Rezoning Transportation Analysis

Petition Number: 2020-169

General Location Identifier: Tax ID: 15705424

Revision Log:	Date	Description
	11-30-20	First Review (WB)
	12-28-20	Second review (WB)
	01-26-21	Third Review (WB)

DEVELOPMENT STANDARDS

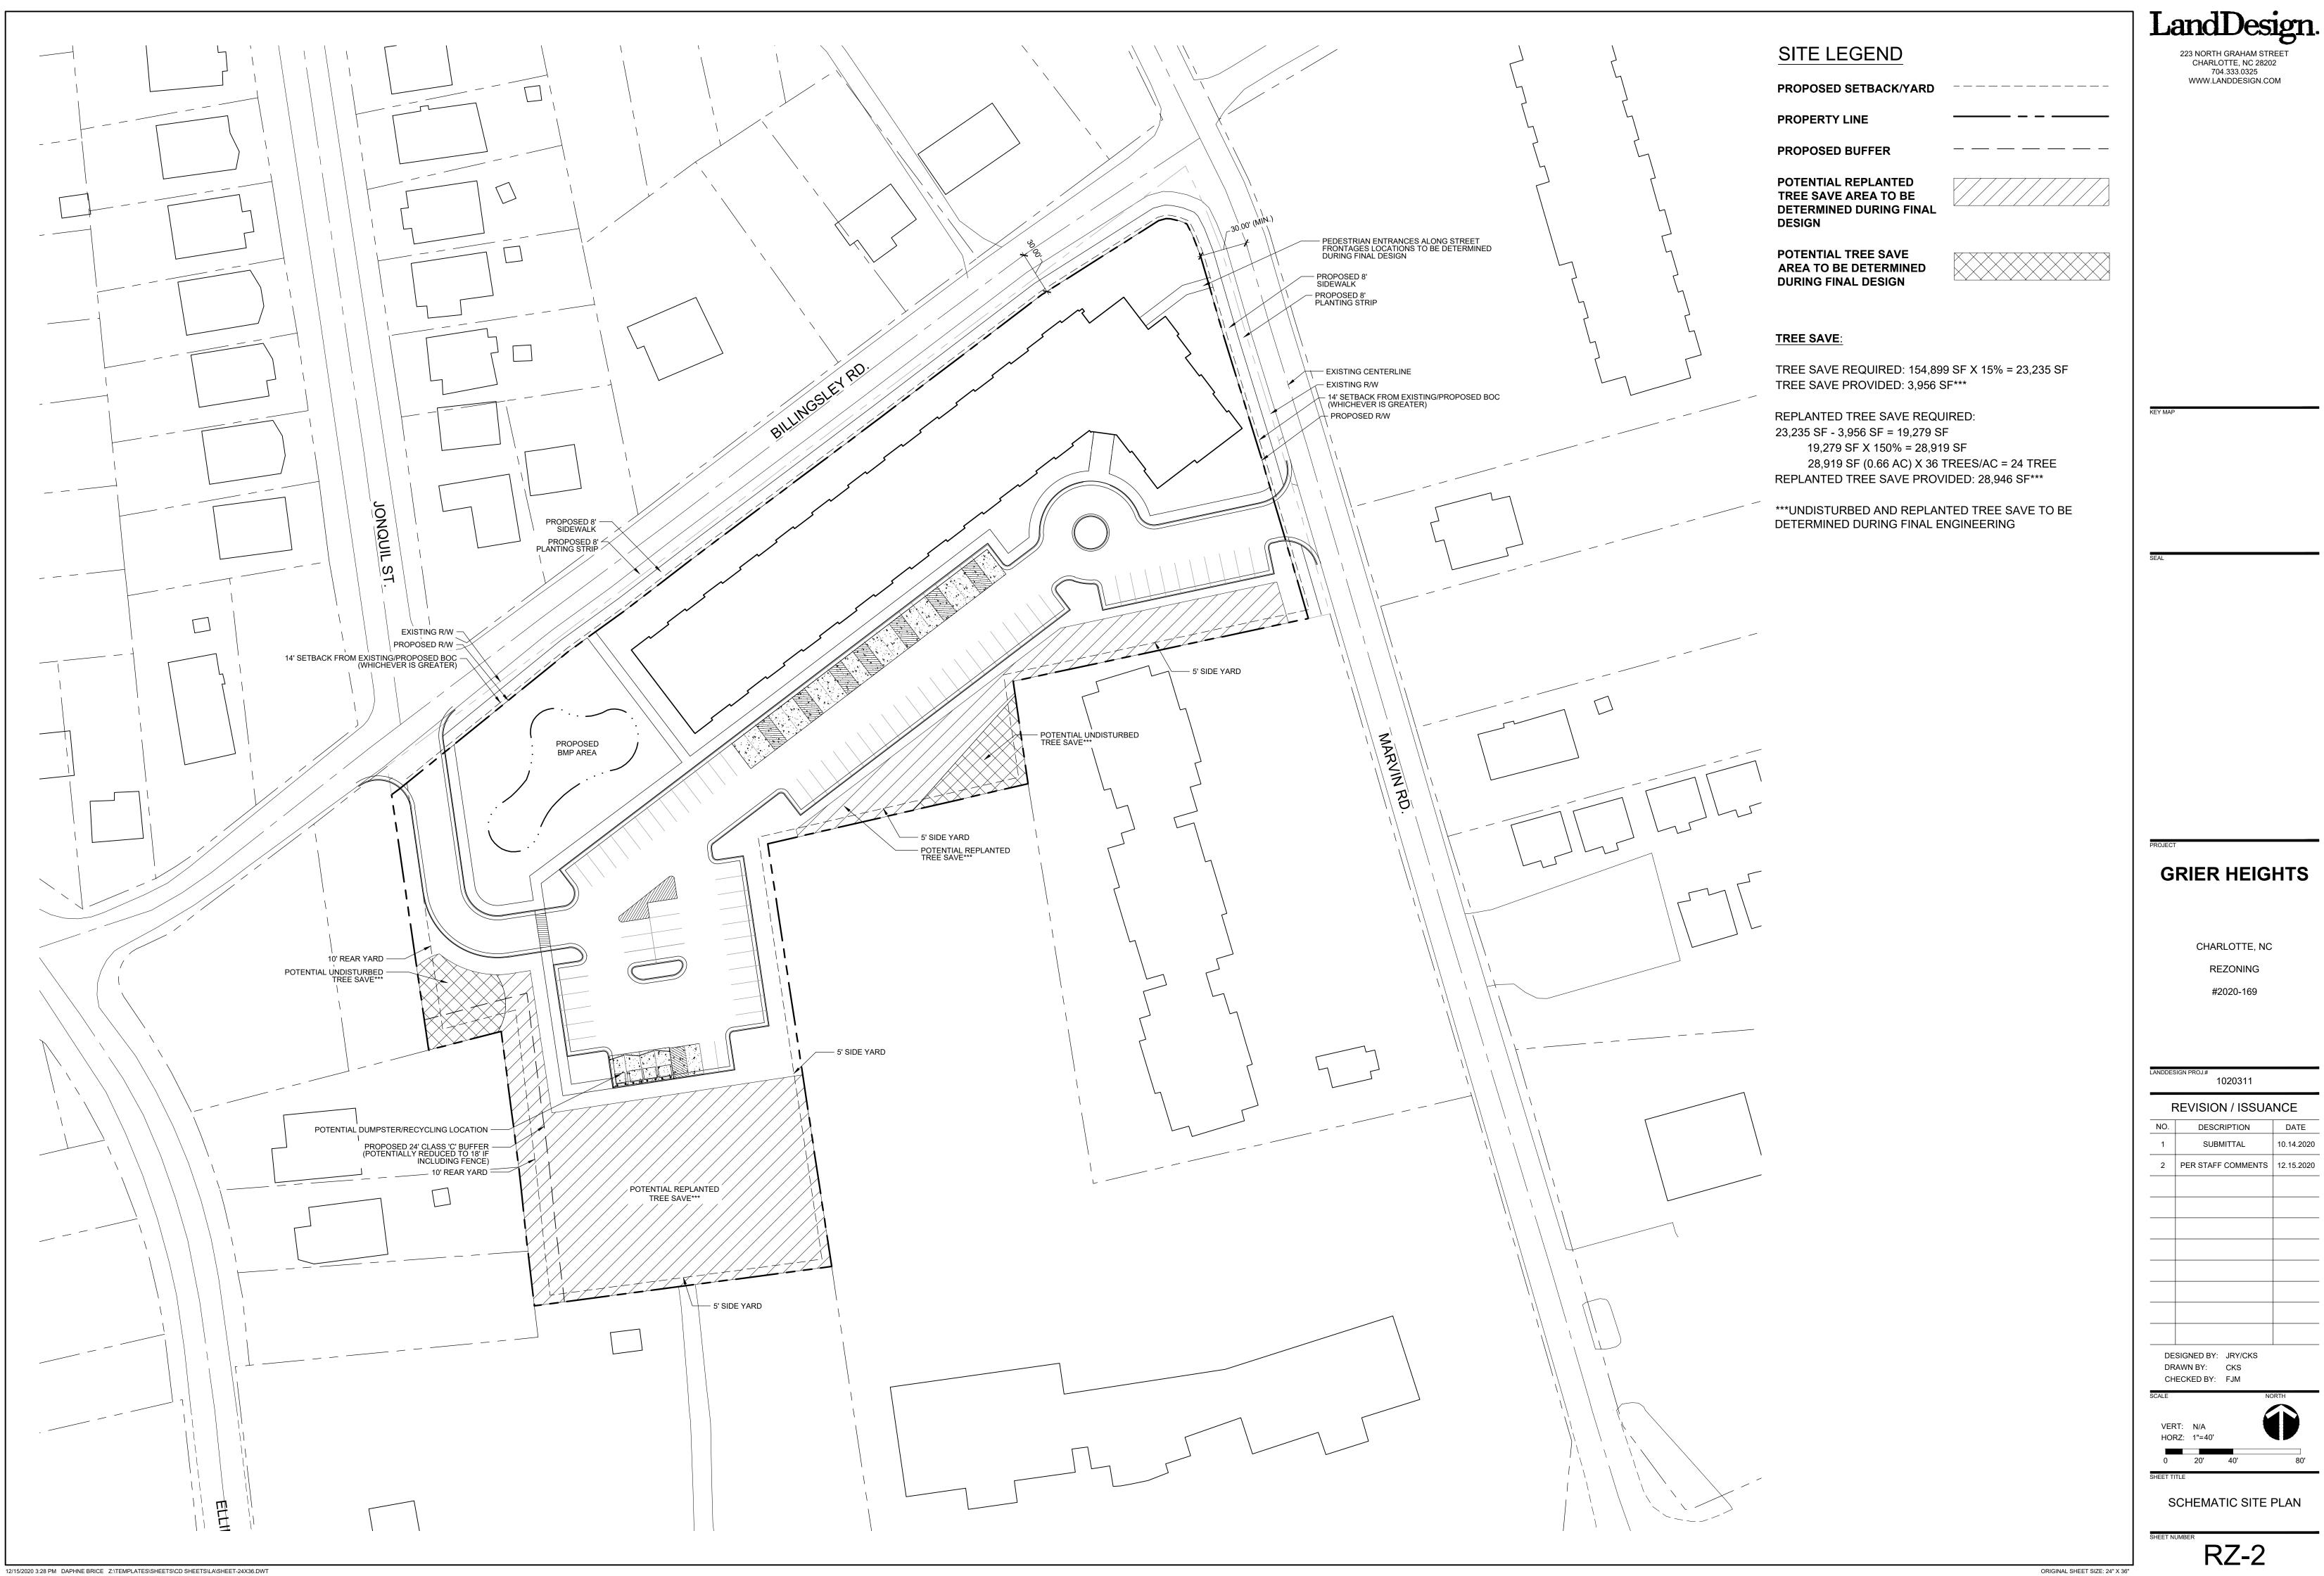
1. ~~**Curblines:** The proposed zoning district has a setback measured from back of the existing or proposed future curblines.~~
 - a. ~~**Billingsley Road:** The future location of curb and gutter is in its existing location. Label and dimension the curb and gutter from the centerline for each road on the site plan.~~

- b. ~~**Marvin Road:** The future location of curb and gutter is in its existing location. Label and dimension the curb and gutter from the centerline for each road on the site plan.~~

3. ~~Revise site plan and conditional note(s) to commit to dedicate 30' (minimum) right-of-way from the road centerline. The site plan shall label and dimension the right-of-way from the road centerline.~~

4. ~~The proposed dwelling units exceeds 12 per acre. Per Chapter 20 Subdivision ordinance, site plan and conditional note(s) revisions are needed to commit to construct an 8-foot planting strip, and 8-foot sidewalk along Billingsley Road and Marvin Road. The wider sidewalk also meets the Charlotte WALKS Policy.

Reference (CLDSM standard detail U-05) for street typical.~~
5. ~~Add a site plan note specifying dedication and fee simple conveyance of all rights-of-way to the City before the site's first building certificate of occupancy is issued is needed. CDOT requests rights-of-way set at 2' behind back of sidewalk where feasible.~~
6. ~~Add a site plan note specifying that all transportation improvements will be approved and constructed before the site's first building certificate of occupancy is issued is needed. The petitioner may phase transportation improvements if said improvements and phasing are explicitly described in site plan notes.~~
